From: Geoffrey Winch [REDACTED]
Sent: 16 March 2022 10:45
To: Planning <Planning@arun.gov.uk>
Subject: FP/274/21/OUT - Bognor Regis Golf Course Proposals - OBJECTION

Site Access (Principles).

Project:	JNY10830 Bognor Regis
Title:	Downview Road/ Felpham Way (B2259) Junction
Location:	
Additional detail:	
File name:	Downview Road_Felpham Way (B2259) Junction (Proposed Model).lsg3x
Author:	George Magnisalis
Company:	RPS Group
Address:

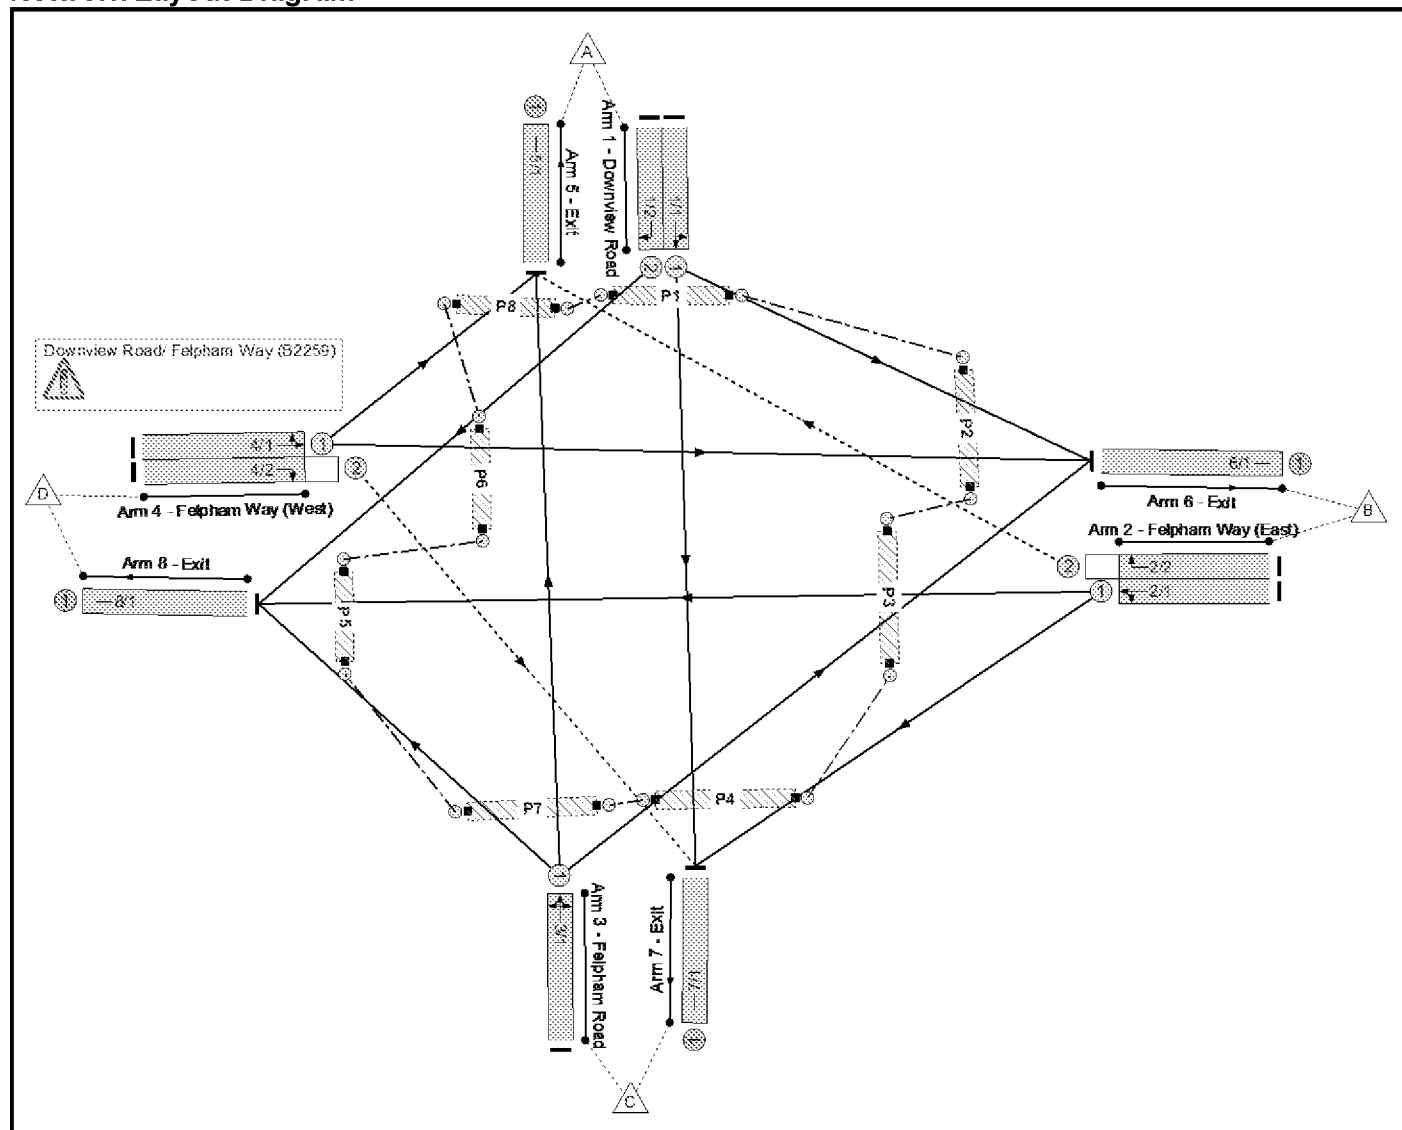
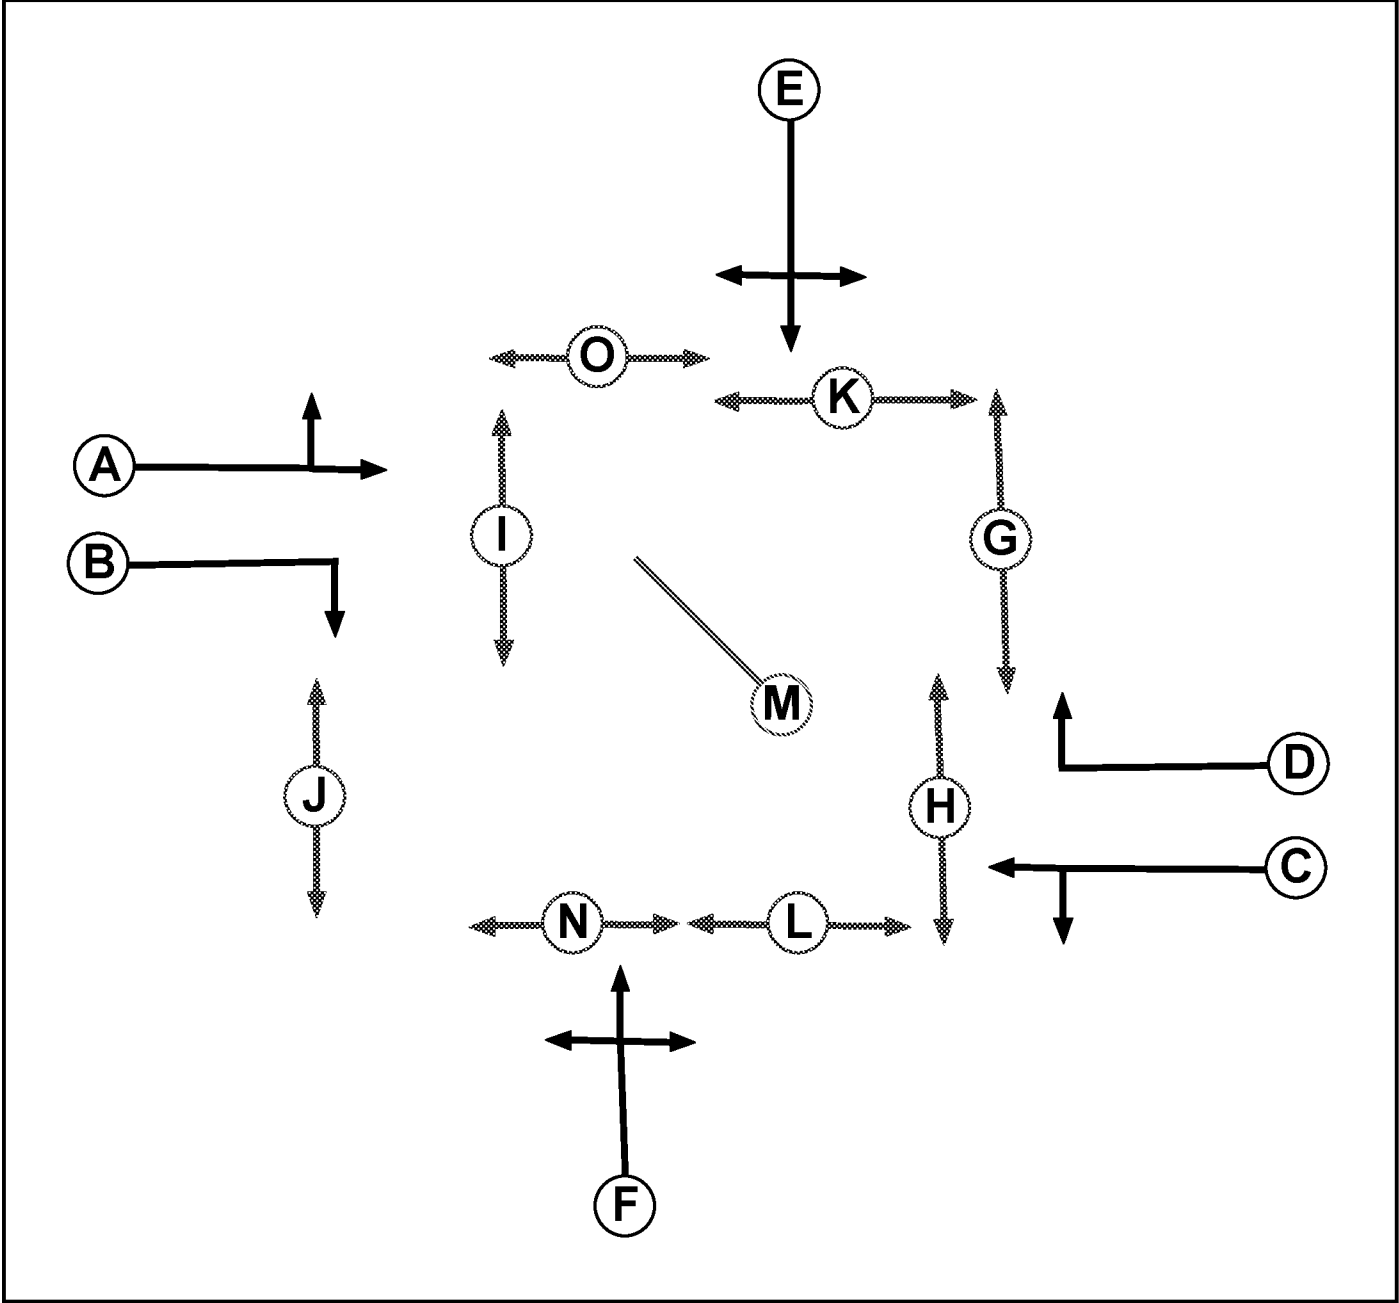
The TA presents a modified LINSIG output to demonstrate the effective operational efficiency or otherwise of the MOVA signaled junction. The results show that, at present the junction performs within its design capacity, although some arms are approaching saturation (i.e. in excess of 85%) with a 120 second cycle time. (85% normally signals a warning to modelers that a junction's design capacity is being approached, and 100%+ that a junction is failing to perform within its design capacity.)

In order for the junction to operate within its design capacity the TA proposes introducing a more complex phasing sequence which will result in the two separate pedestrian phases across both Downview Road and Felpham Road. This will require pedestrians needing to be corralled safely within staggered crossing island refuges between phases. The TA fails to demonstrate that proposed refuges are of a sufficient size to safely corral the relevant numbers of people, or the lengths of time they will need to be corralled.

The LINSIG programme provides information about actually observed and predicted vehicle queue lengths. Relevant queue lengths are considered, as a rule of thumb, to be the mean maximum length that remains once a green phase for a particular arm ends. Actual observed average queue lengths are usually estimates inasmuch that the backs of queues can be very fluid and a judgement has to be made by the observer as to which vehicles are actually queueing as the phase ends – particularly difficult if the queue is moving slowly – and which are effectively just joining the queue. It can be assumed, however, that the maximum length within some sequences could be twice the average as stated, and in some sequences there might be no queues. There are numerous variables which affect queue lengths so there is likely to be some considerable variation to the numbers given in any forecast during any one hour period.

With these factors in mind I undertook some personal observations on Wednesday 9th March 2022 during the end of school peak hour for comparison with the TA's PM peak. Accepting that there may have been queue lengths twice the length of the average I have doubled the number stated in the TA. I therefore record the following: Maximum queue observed lengths in Downview Road 18 (TA) compared to 38 (mine)(not including 6 cars queued in Goodwood Avenue waiting to join the queue); Felpham Way (East) 24 (TA) compared to 30 (mine); Felpham Road 6 (TA) compared to 20 (mine), and Felpham Way (West) 30 (TA) compared to 40+ (mine), and on this link I know from experience that it becomes saturated within the end of school peak when delays at the junction adversely impact on the operational efficiency of the Drygrounds Lane Close roundabout.

Therefore I conclude that had modelers tested for the end of school day peak, then the results are likely to have demonstrated a far less operational efficiency than that suggested in the TA's prediction for the PM peak.
